COMMUNITY DEVELOPMENT DEPARTMENT
501 Delta Avenue ♦ Marysville, WA 98270 ♦ (360) 363-8000

Re: PA23-015 – MSR Tuscany Woods Townhomes – Technical Review 1

RE: MSR Tuscany Woods Townhomes, File# PA23-015
Proposed 37-unit townhome development, utilizing Residential Density Incentives to achieve 11 bonus units, and associated improvements. Access proposed from 84th Street NE.
4407 84th Street NE & Parcel #30052100105200

SW 1/4, NE 1/4, SEC.21, T.30N., R.5E., W.M.  
**MSR TUSCANY WOODS**  
DWG FILENAME: 221215-PRELIM.DWG DESIGNED BY: DJK DATE: 05-10-2023 SCALE: 1"=40' JOB NO.: 22-1215 SHEET  
PRELIMINARY ROAD, DRAINAGE AND UTILITY PLAN  
CI

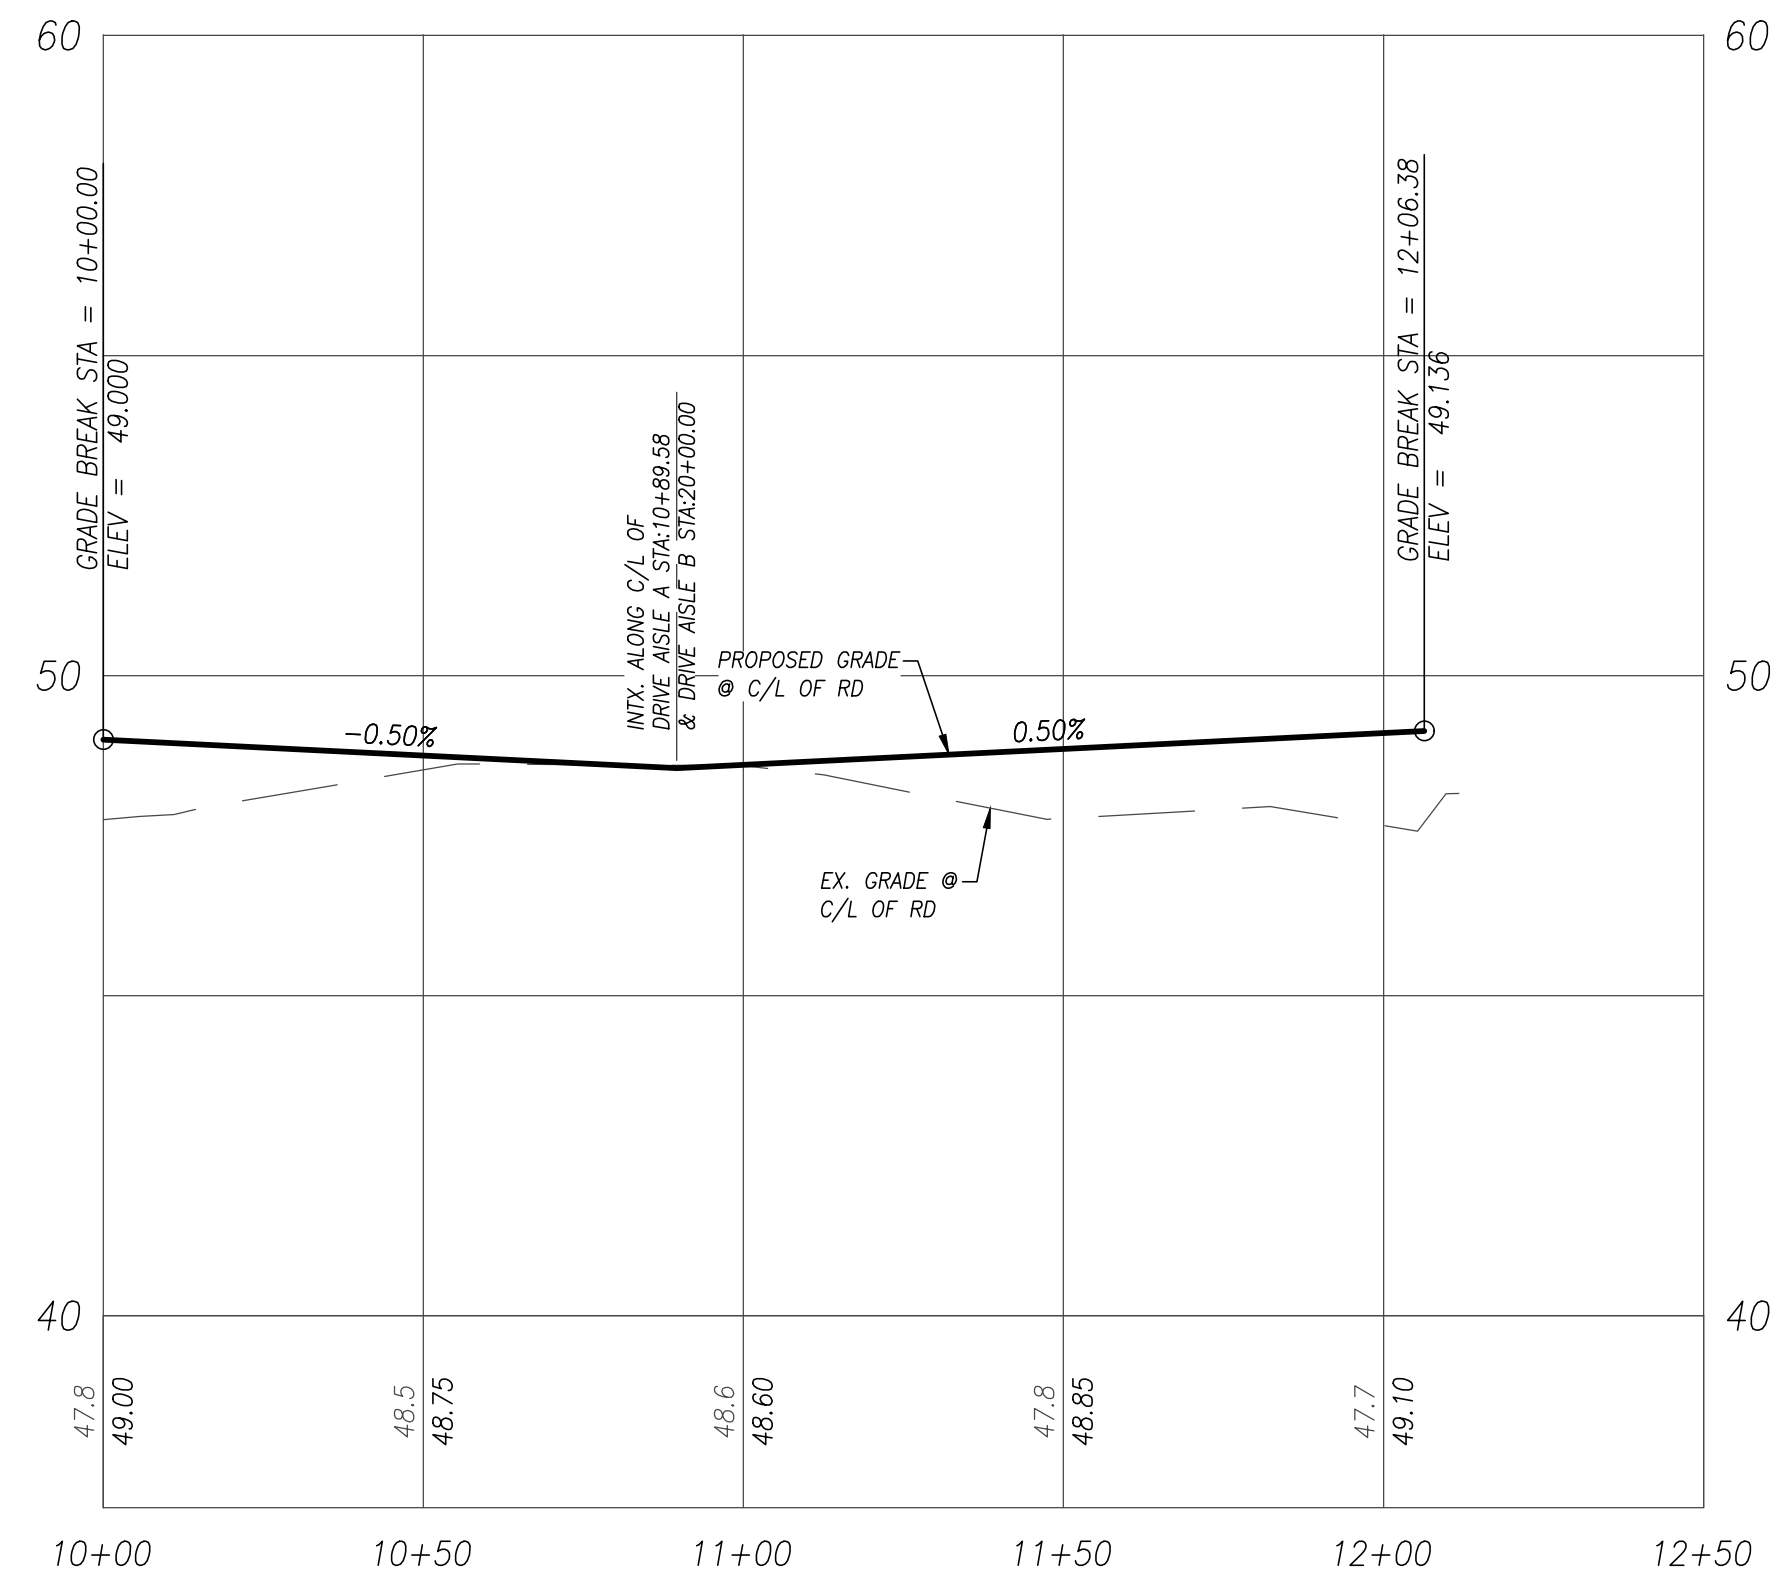
- a. The 6" cast iron water main will need to be upsized to an 8" along the project's frontage.

SITE PLAN **S1**

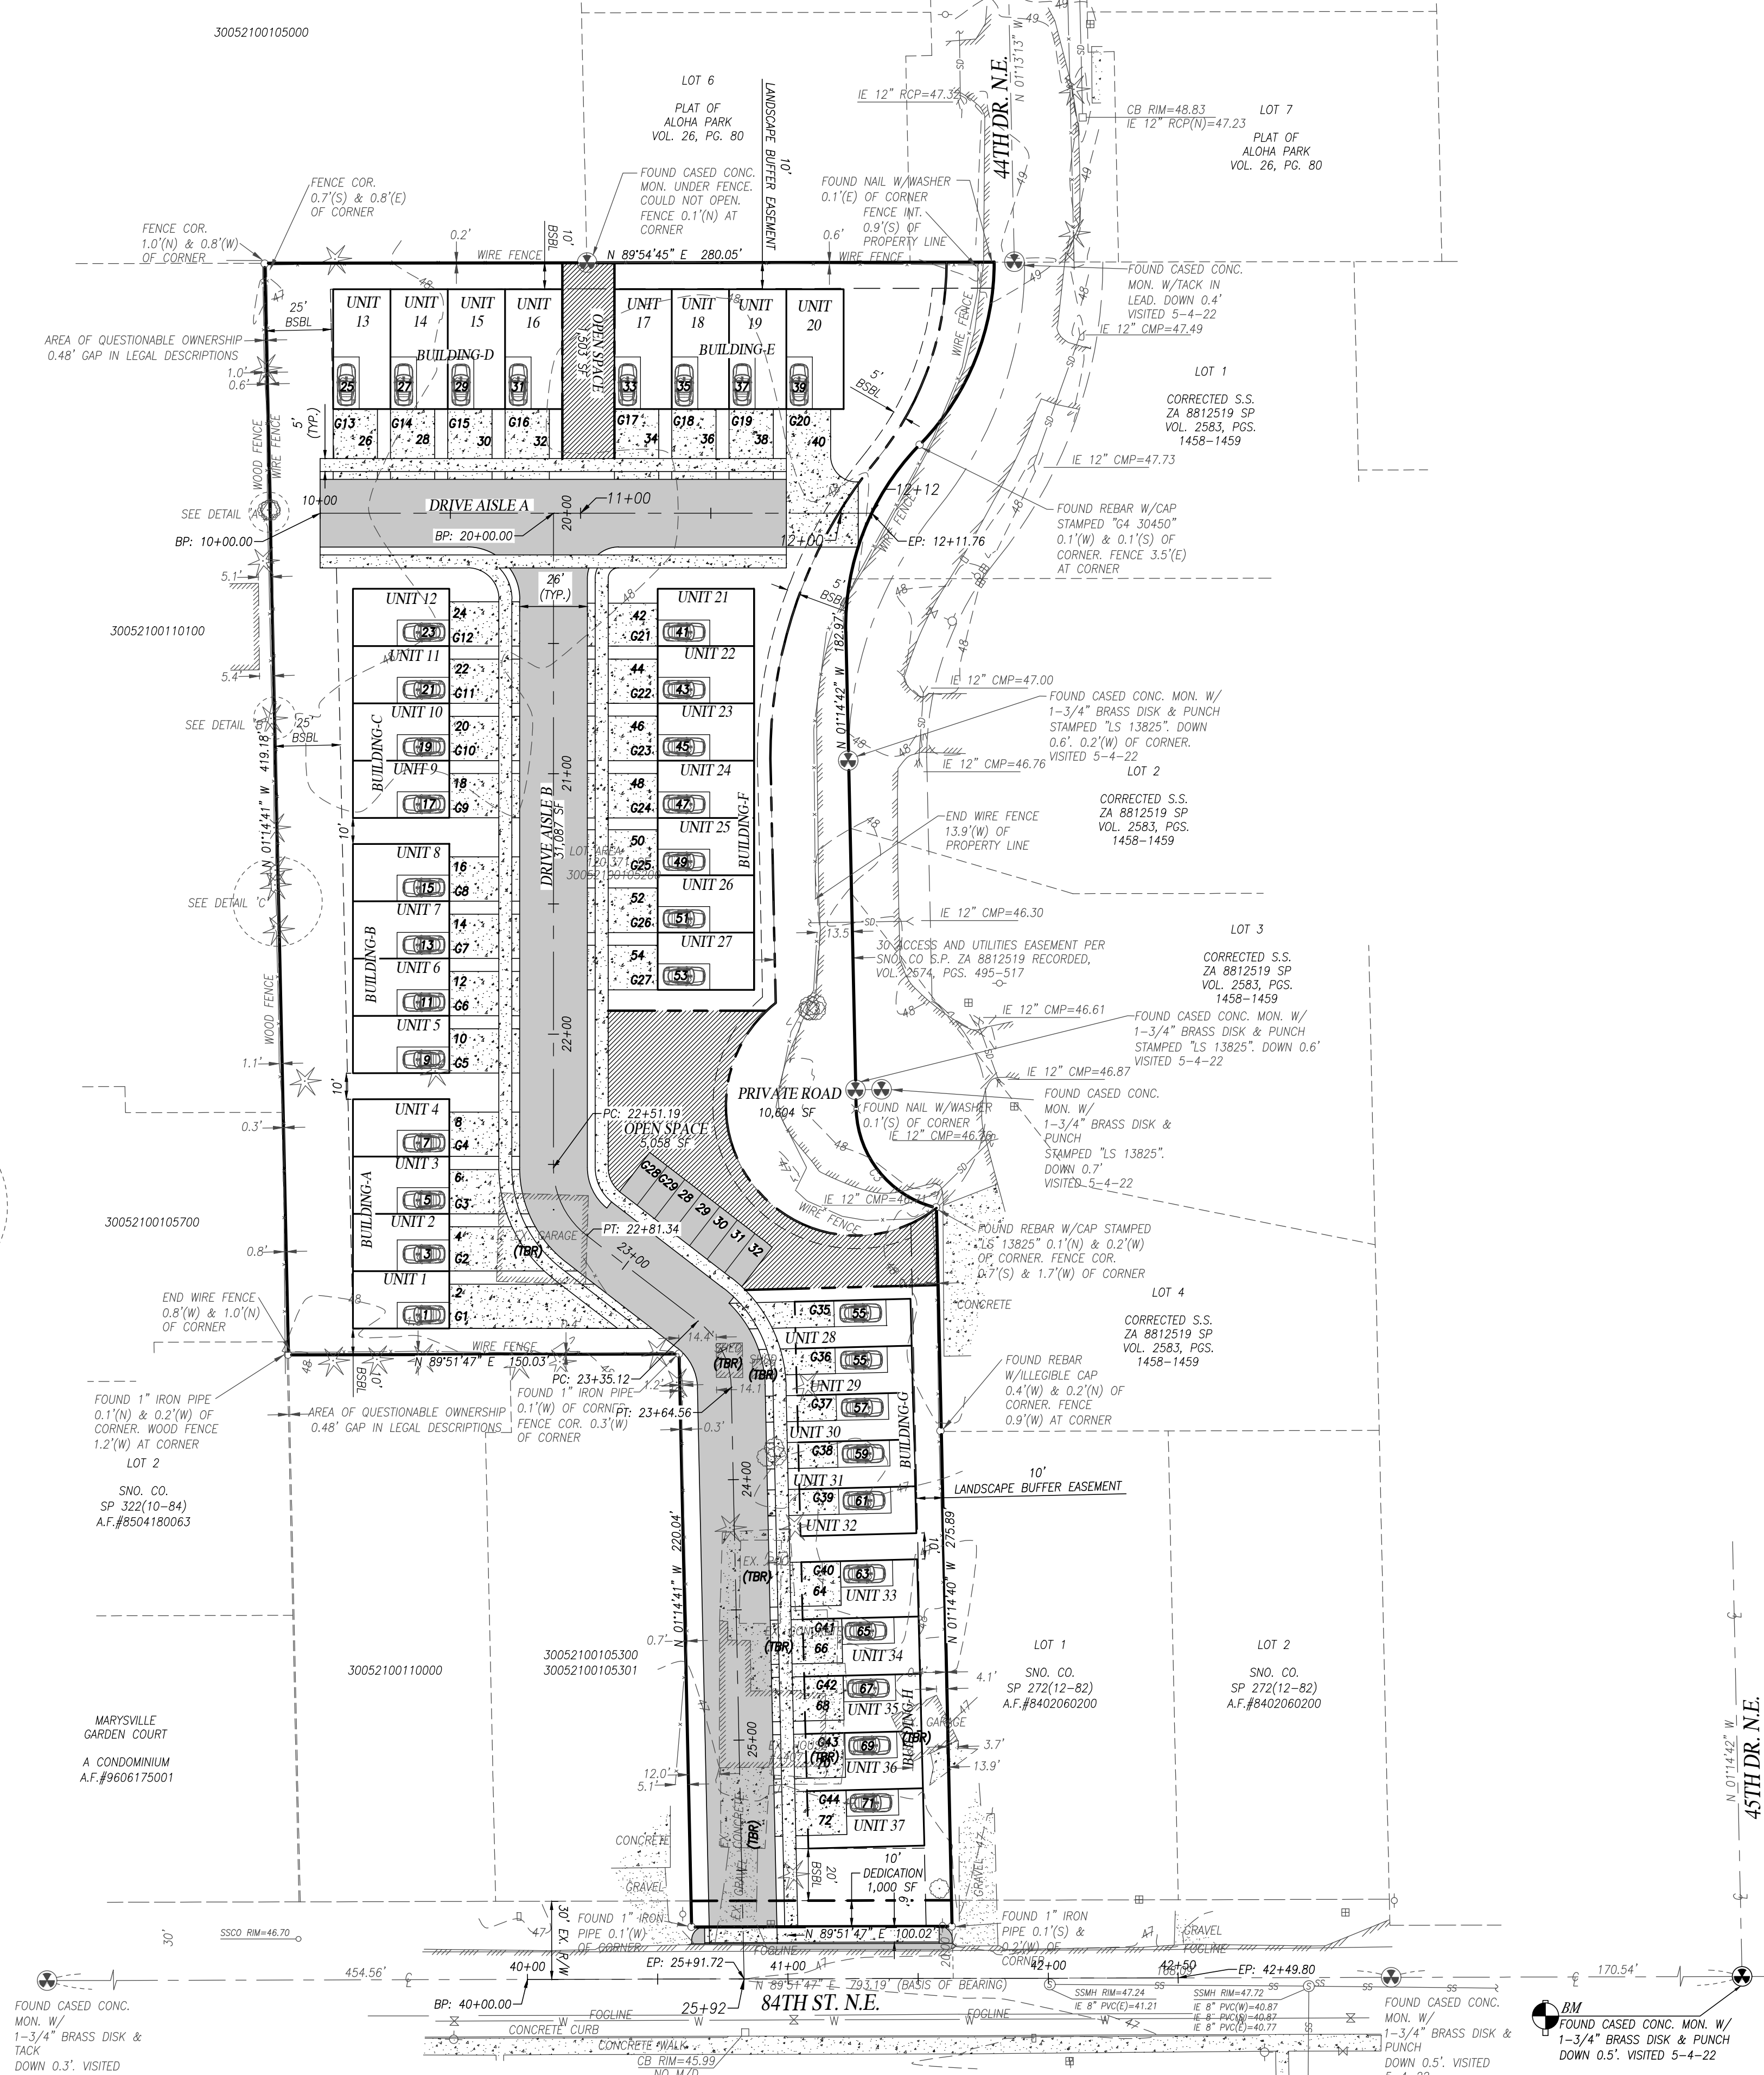
2. The proposal includes use of residential density incentives (RDI) in order to obtain eleven (11) bonus units. As noted in the Pre-application comments, and consistent with MMC 22C.090.050(4), fractional dwelling units earned shall be rounded *down*. The density calculation shall be revised rounding fractional units earned down, and additional incentives identified in order to achieve 11 total bonus units needed for 37 townhome units. Please also identify the areas and lineal feet of fencing/landscaping proposed for bonus units.

3. Rear yard setbacks in the R-12 zone are 25 feet. Please revise the rear yard setback for buildings D and E to meet this requirement.
4. Side yard setbacks in the R-12 zone for properties adjacent to R-6.5 zoned properties are 20 feet. Please revise the setbacks for buildings F, G, and H to meet this requirement.

5. The side yard setback for Unit 1 shall be 10 feet, please revise accordingly.
6. Unit 37 shall be oriented towards 84th Street NE, including primary entry and windows, and shall provide a pedestrian path connecting the unit to the public sidewalk. Access for unit 37 shall be from the internal drive.

7. Schedule B of the title report identifies a PUD easement. Please depict all easements on the site plan.
8. Any/all encroachments shall be remedied prior to final approval. Any contested area shall be removed from the total project area and density calculations revised as needed.

9. [MMC 22C.010.330](#) – Townhouse Open Space. Townhouses and other ground based multi-family residential units with individual exterior entries must provide at least 200 square feet of private open space per dwelling unit adjacent to, and directly accessible from each dwelling unit. This may include private balconies, individual rear yards, landscaped front yards, and covered front porch areas. Exception: Common Open Space designed in accordance with MMC [22C.010.320\(1\)](#) may substitute for up to 50% of each unit's required private or semi-private open space on a square foot per square foot basis. Please provide a plan demonstrating compliance with this requirement. It does not appear that units 28-37 have any private open space.

10. The Horseshoe Court is not easily accessible. MMC 22C.010.320 requires open space to provide usable, accessible, and inviting open space accessible to *all* residents. This area is 'hidden' behind unit 28 and the parking area, and only accessible from one access point, which does not meet the intent.

11. Required setbacks and landscaping shall not be counted towards the common open space.
12. Please provide a revised plan identifying required open space and identify that which is proposed for bonus units.
